Proposal: Removal of existing shed in the rear garden and construction of a detached garage and detached garden room to the rear of property at 33 Lyndale Avenue Wilpshire BB1 9LP

Planning application No: 3/2023/0279

Proposed Site Plan

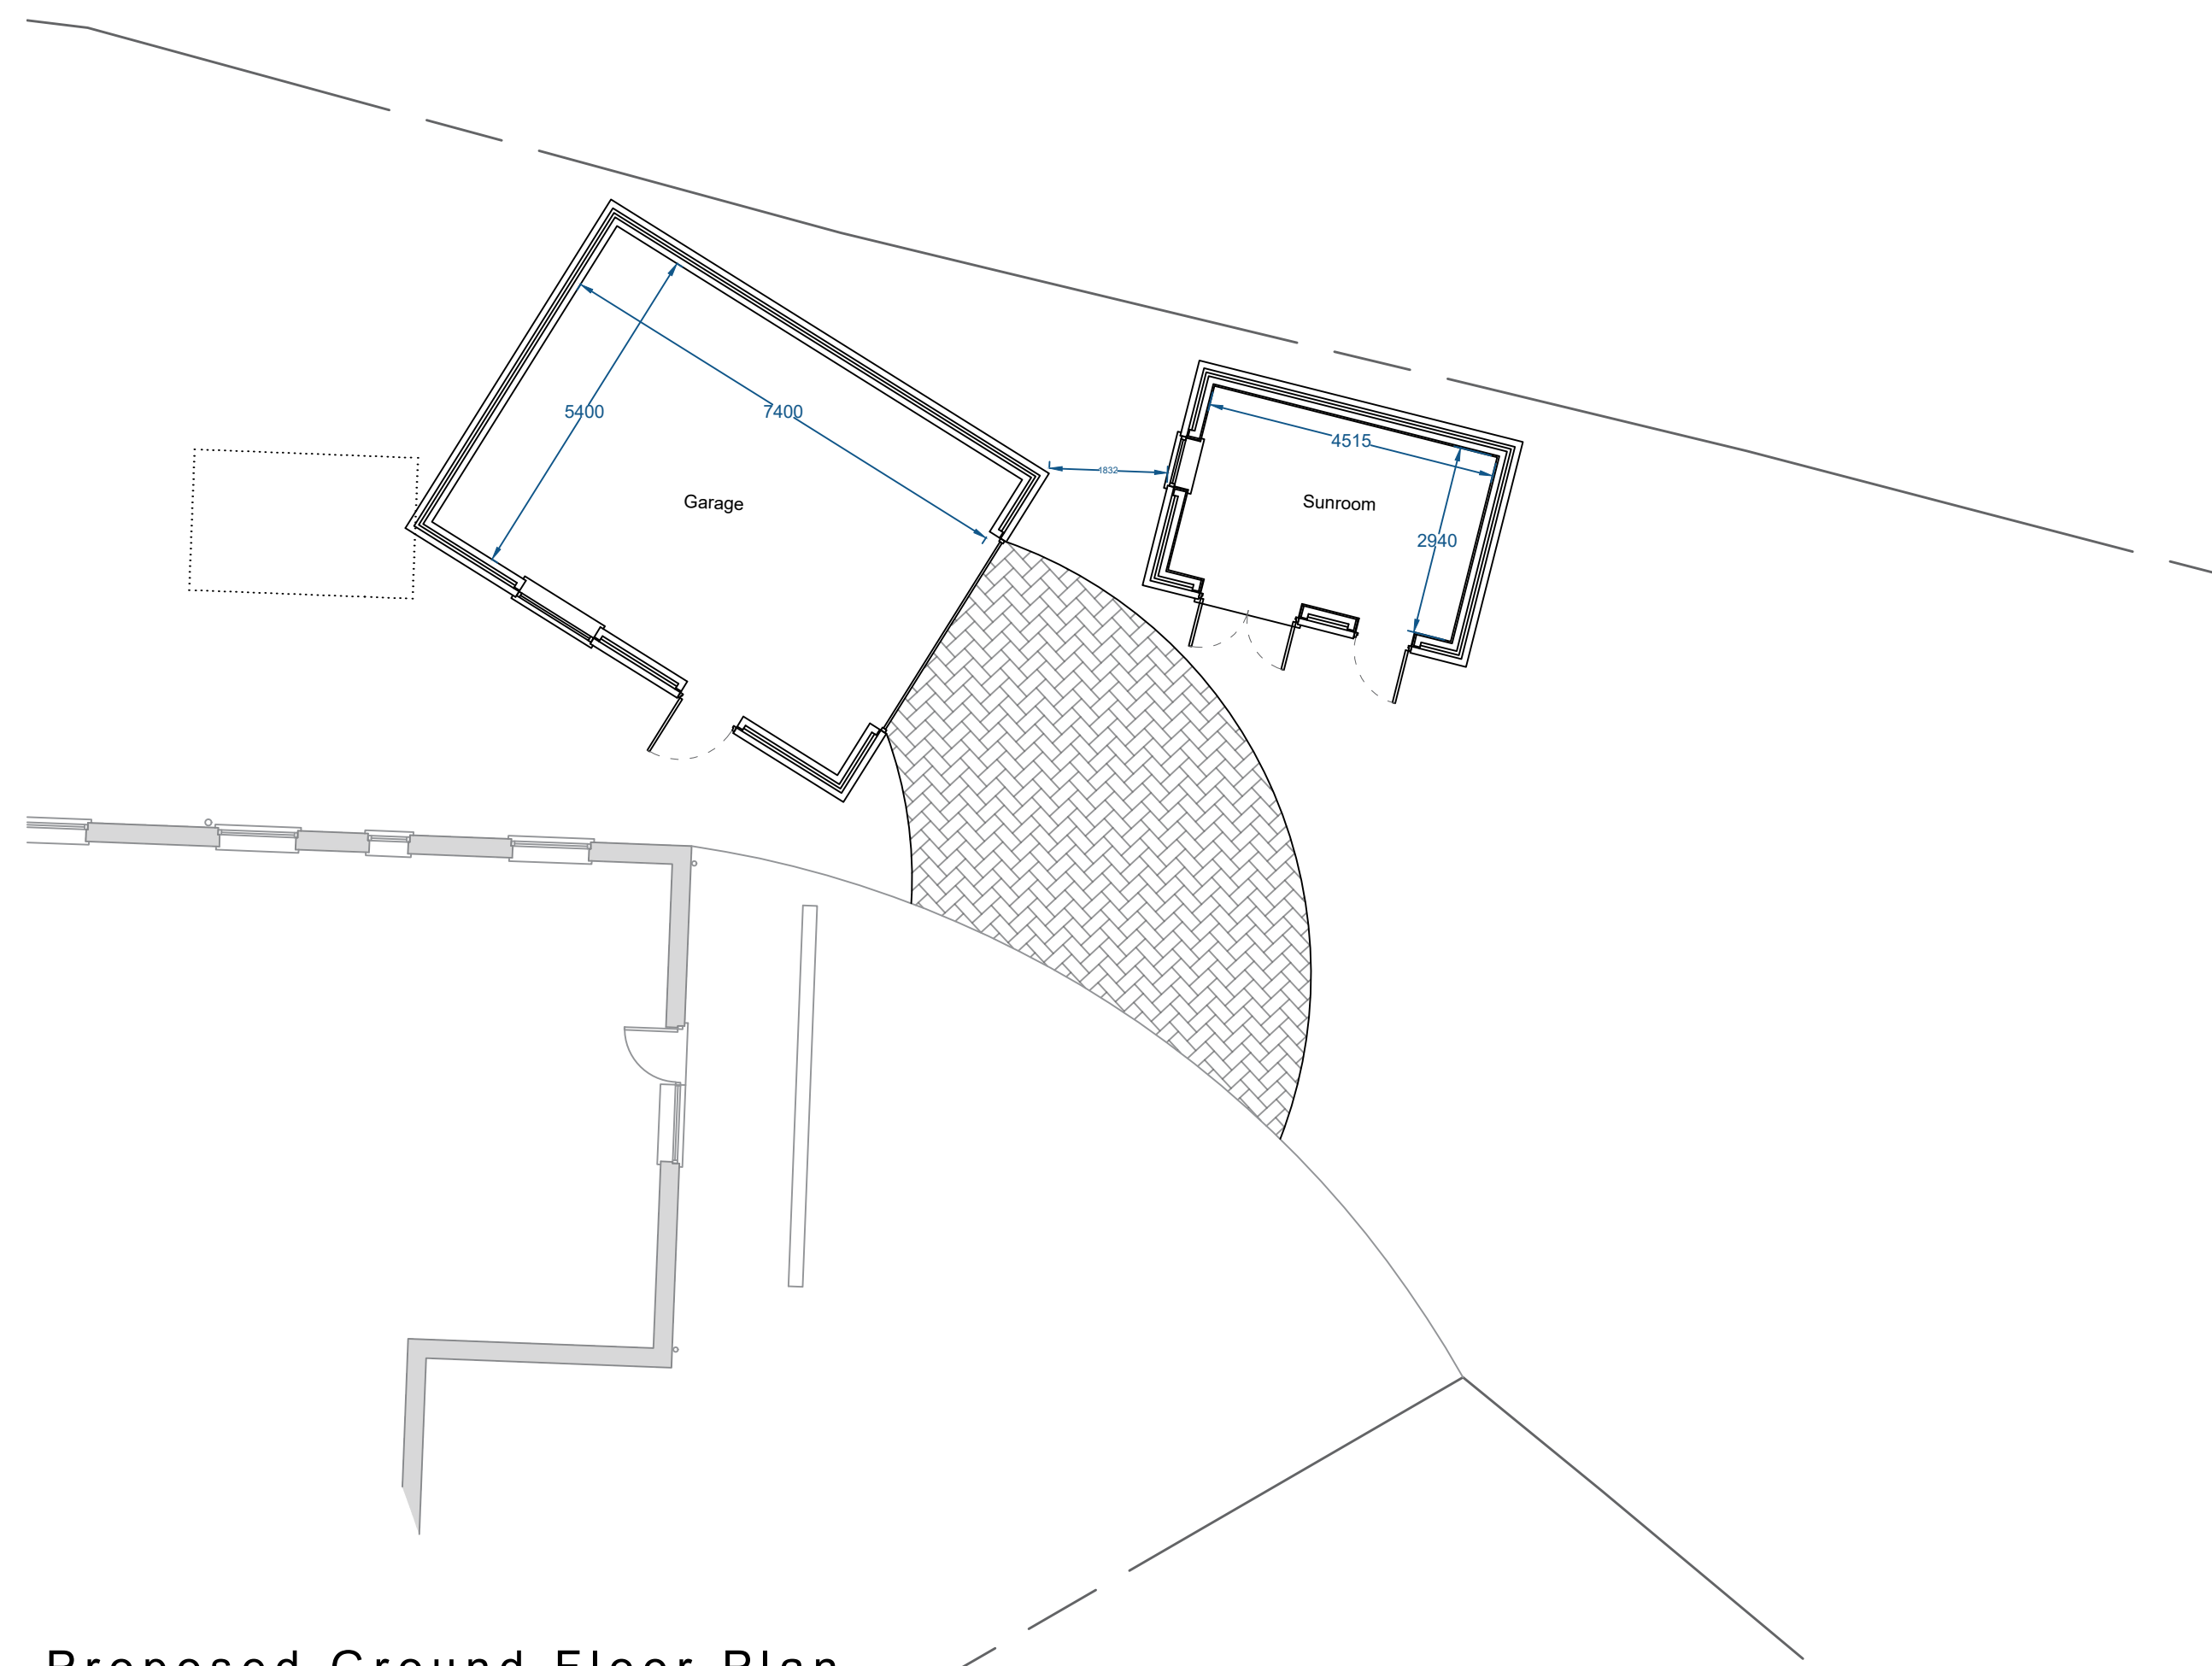
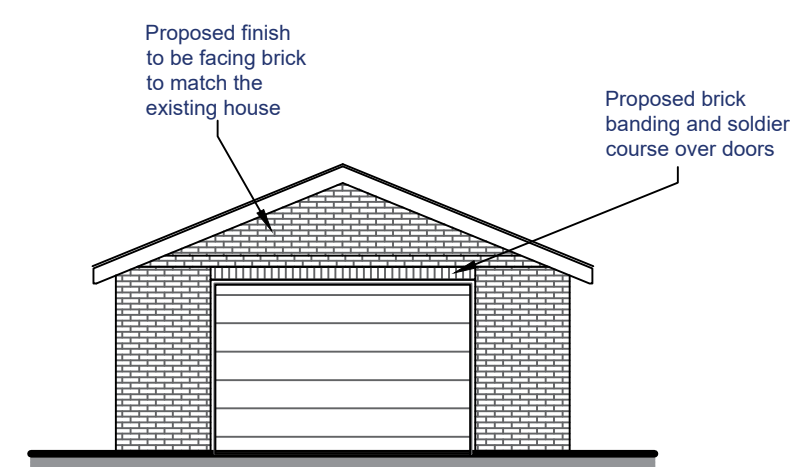
- 1: The plans submitted with the application are not detailed enough and are inaccurate in respect to the trees and shrubs situated in the applicant's garden [REDACTED]

- 2: In the submitted application form they have have stated that; there are no trees within falling distance of the buildings, or there is no requirement for trees or hedges to be removed. I believe that both these statements to be incorrect.

4. No dimensions are given for the exact placement in relation to the properties boundaries. However, from scaling the drawing I would suggest that the garage is close to 500mm [REDACTED] Given the overall dimensions of the garage this particular structure is not a lot smaller than the dwelling that it would share the site with. I therefore assert that the proposed development, by virtue of its proximity and scale, will result in an unsympathetic and overbearing impact upon the garden area associated with not only mine but my [REDACTED] Therefore being of detriment to the residential amenities of current and future occupiers of our properties.

1. The plans submitted with the application are not detailed enough, ie. no dimensions shown to property boundaries, and are inaccurate in respect to the trees and shrubs situated in the applicant's garden, are not shown.

2. In the applicant's garden there are trees along the boundary line of the property along with some substantial shrubs. However, In the submitted application form they have have stated that; there are no trees within falling distance of the buildings, or there is no requirement for trees or hedges to be removed. I would suggest that both these statements to be false.

Proposed Ground Floor Plan

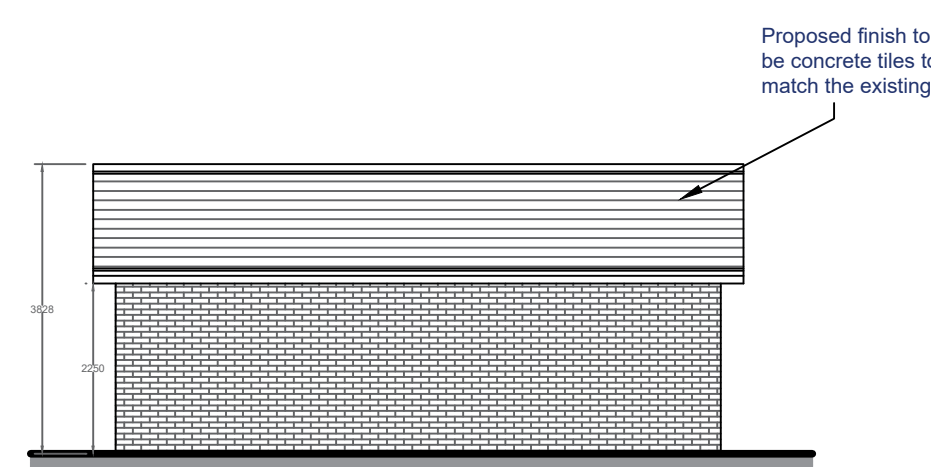
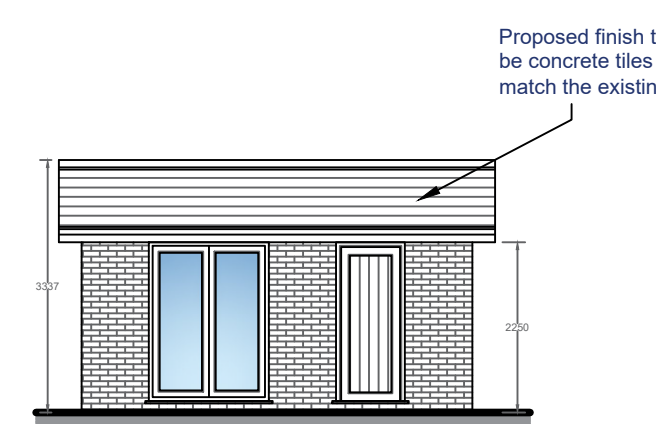
- 4: The overall dimensions given for the garage would mean that it will not be a lot smaller than the bungalow that it will occupy the site with. I would therefore suggest that the proposed development, by virtue of its proximity and scale, will result in an unsympathetic and overbearing impact upon the garden area associated with not only mine but my neighbour's gardens. This therefore suggests that the proposal will have a lasting and detrimental effect for the residential amenities of current and future occupiers of our properties.

3. The overall dimensions of the garage suggest that this particular structure is not a lot smaller than the bungalow that it would share the site with. I therefore put forward the point that the proposed development, by virtue of its proximity to adjacent properties, with its scale and stature, will result in an unsympathetic and overbearing impact upon the garden area associated with not [REDACTED]
[REDACTED] Therefore being of a detriment to the residential amenities of current and future occupiers of [REDACTED] properties.
